Attachment A – Detailed Response to Submissions Table

Attachment A – The Sutherland Hospital Operating Theatre Upgrade (SSD-11099584) – Detailed Response to Submissions Table

LOCATION PLANS

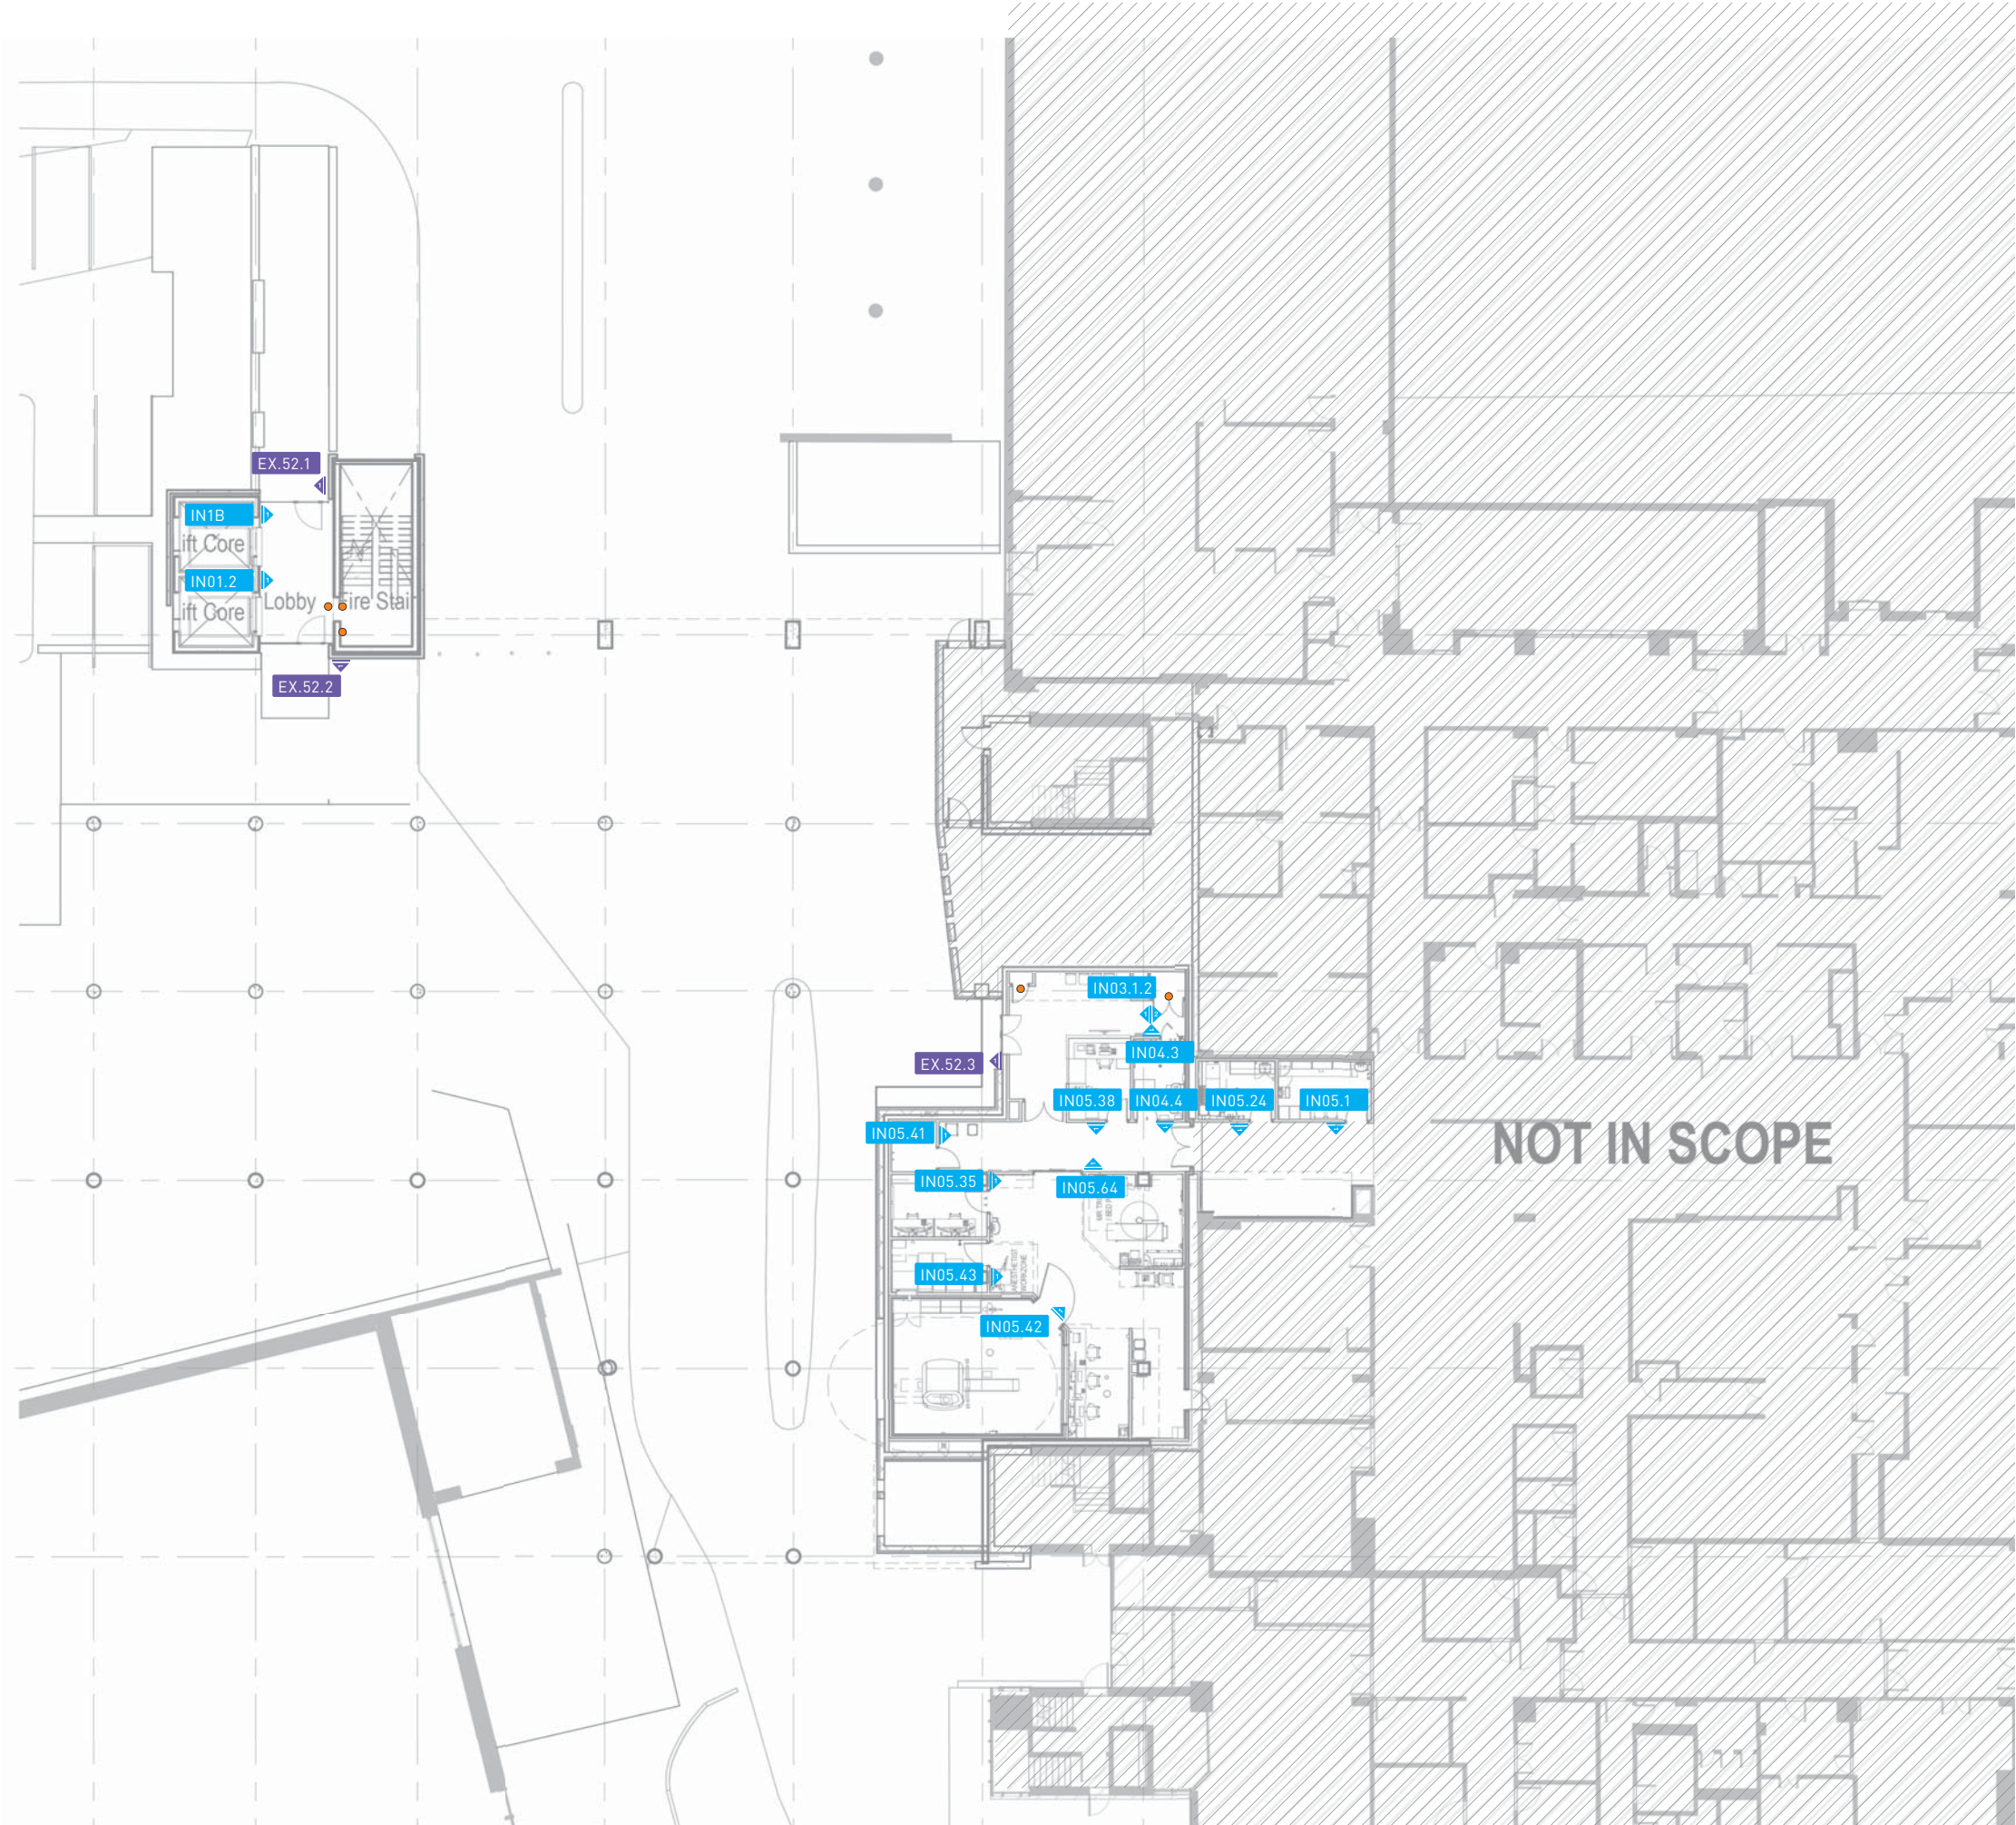
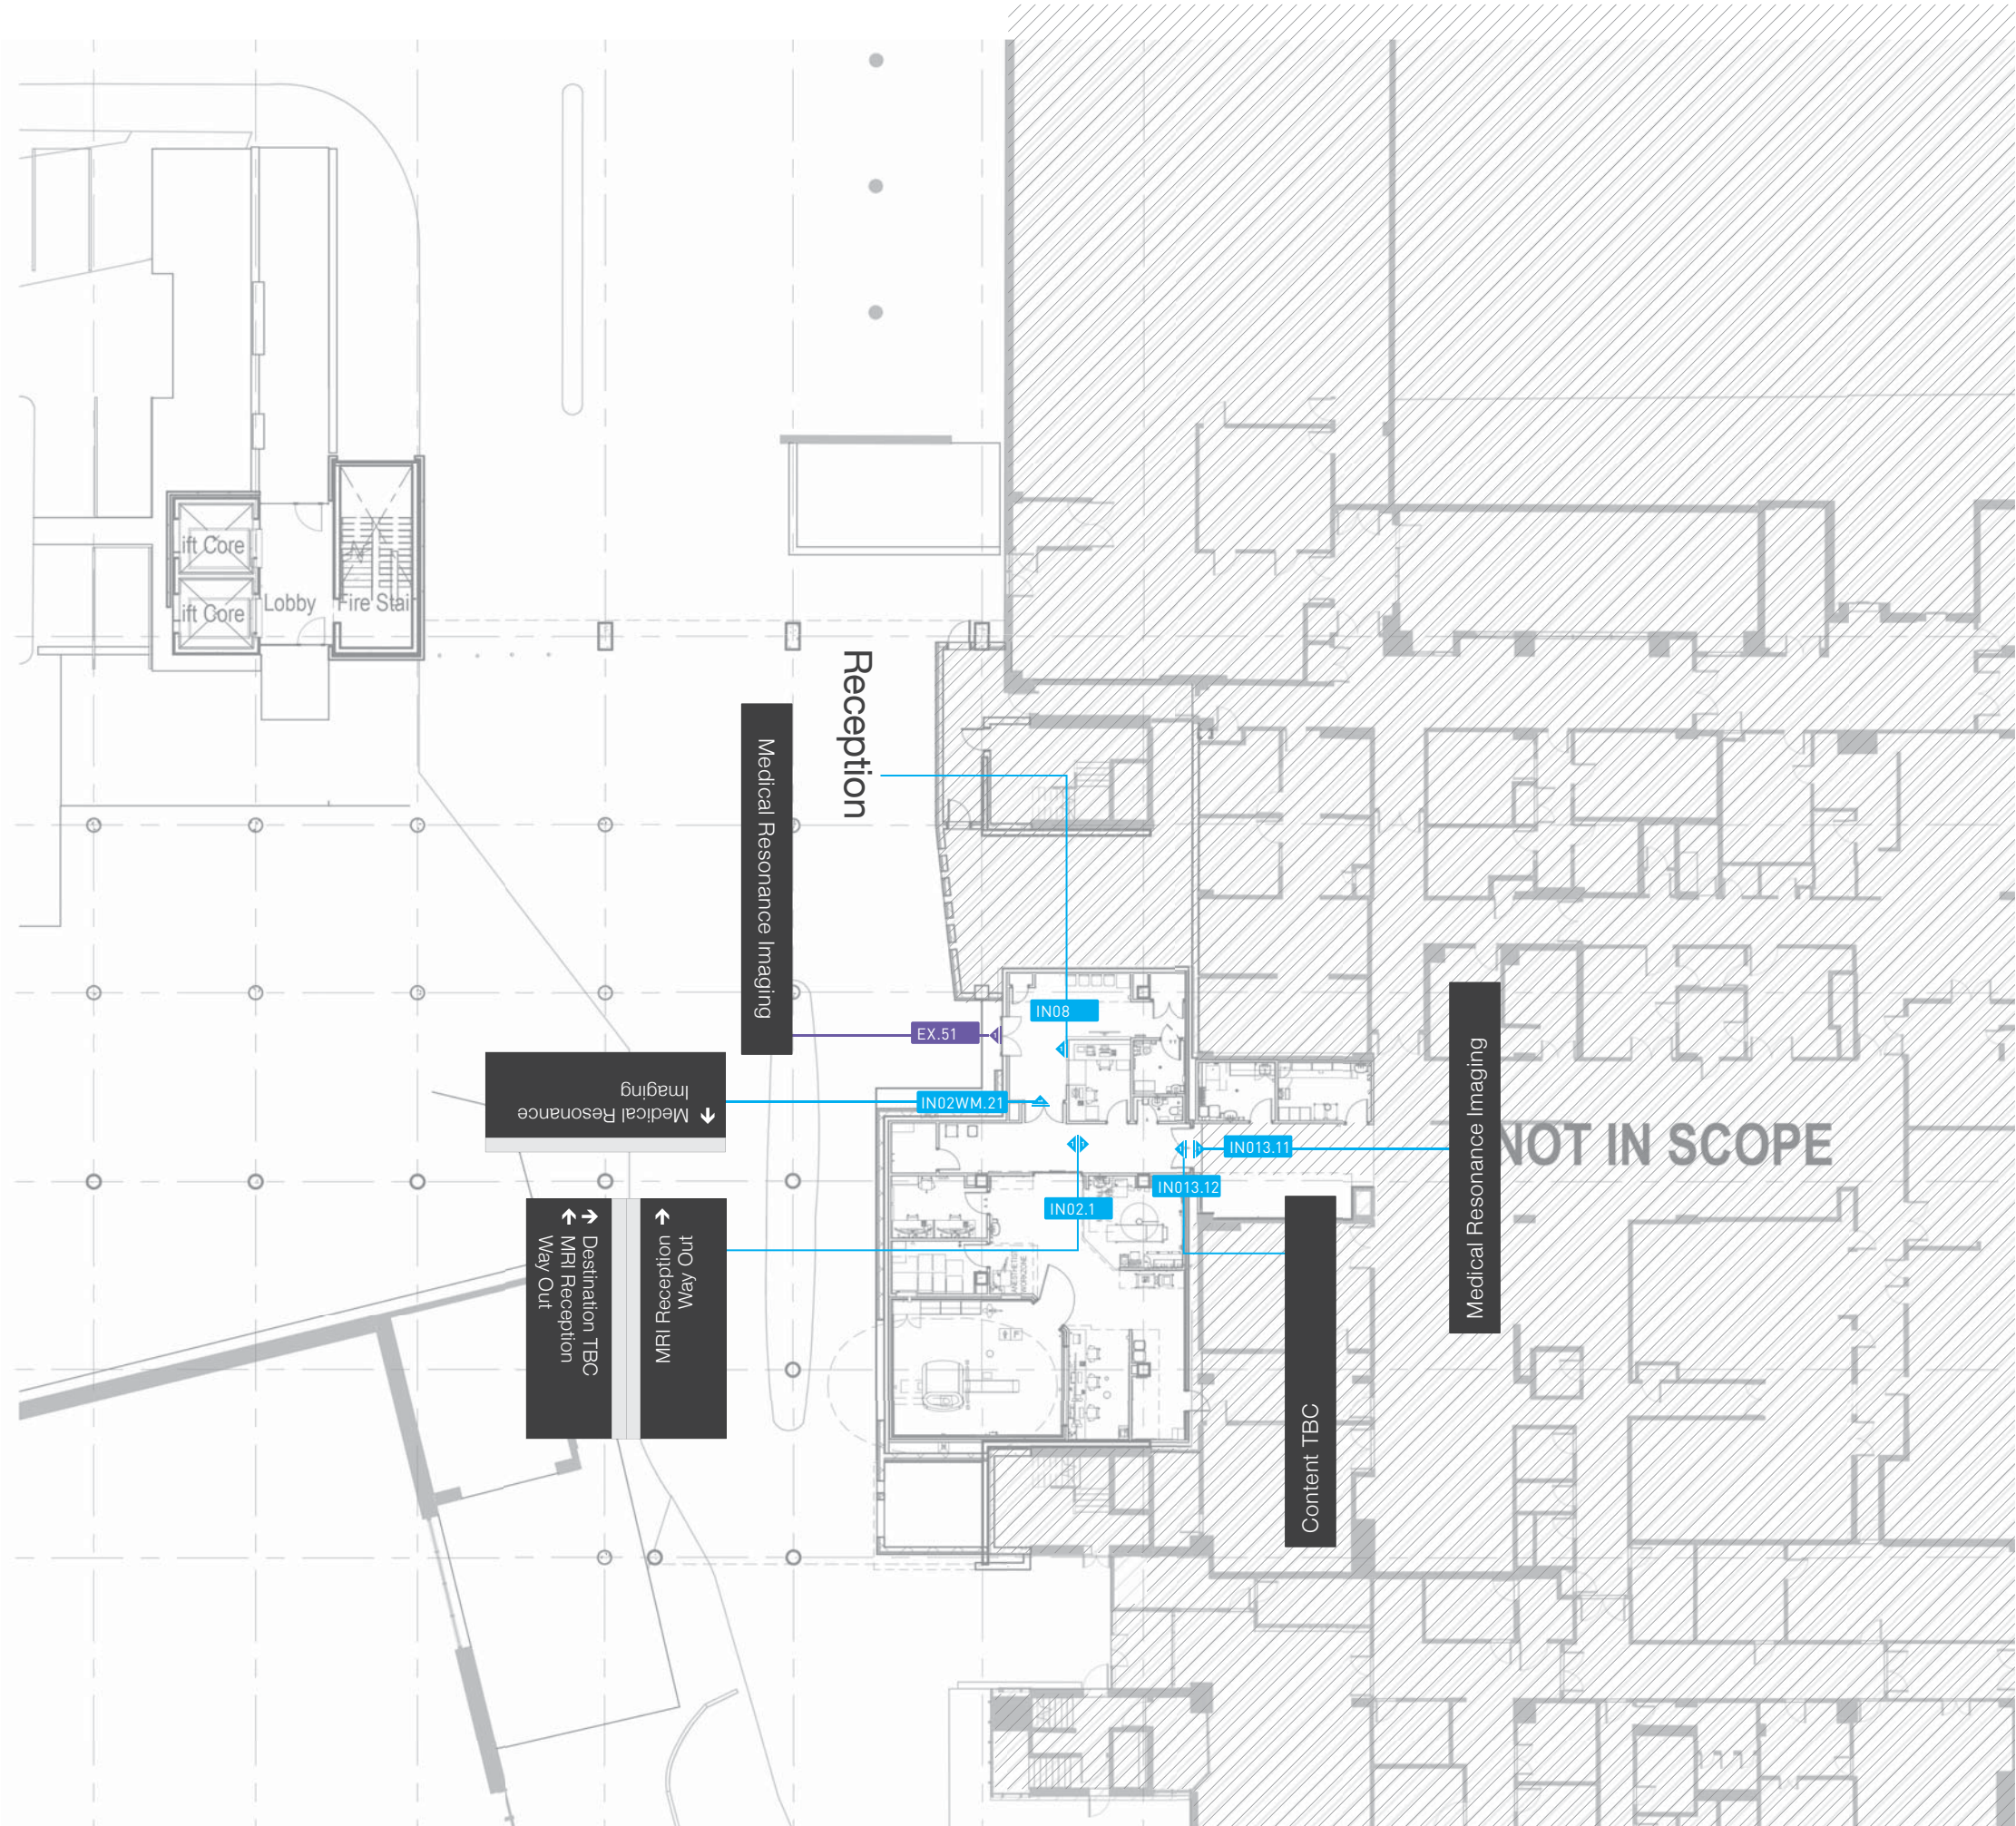
Issue raised in agency submission	Proponent's response
Department of Planning Industry and Environment (DPIE)	
<p>1 Access</p> <p><i>While the main hospital entrance is not being altered or changed in the proposal, the proposal also includes a smaller entrance, which may cause confusion when patients are entering the site. No signage has been included in this proposal but should be incorporated to improve wayfinding across the site.</i></p>	<p>A wayfinding strategy has been developed for the proposed development by Brandculture and is provided at Attachment C and Figure 1 below.</p> <p>The wayfinding strategy provides further information on the legibility of the entrance to the building including the signage to be used at the entrance fronting the car park. As depicted below the signage on this frontage is quite minimal so as to not appear as a key entrance to the public. Note also that the signage notes that Level 1 is for staff only.</p>  <p>Figure 1 Proposed wayfinding signage at the entrance to the operating theatre building. Source: Brandculture</p>
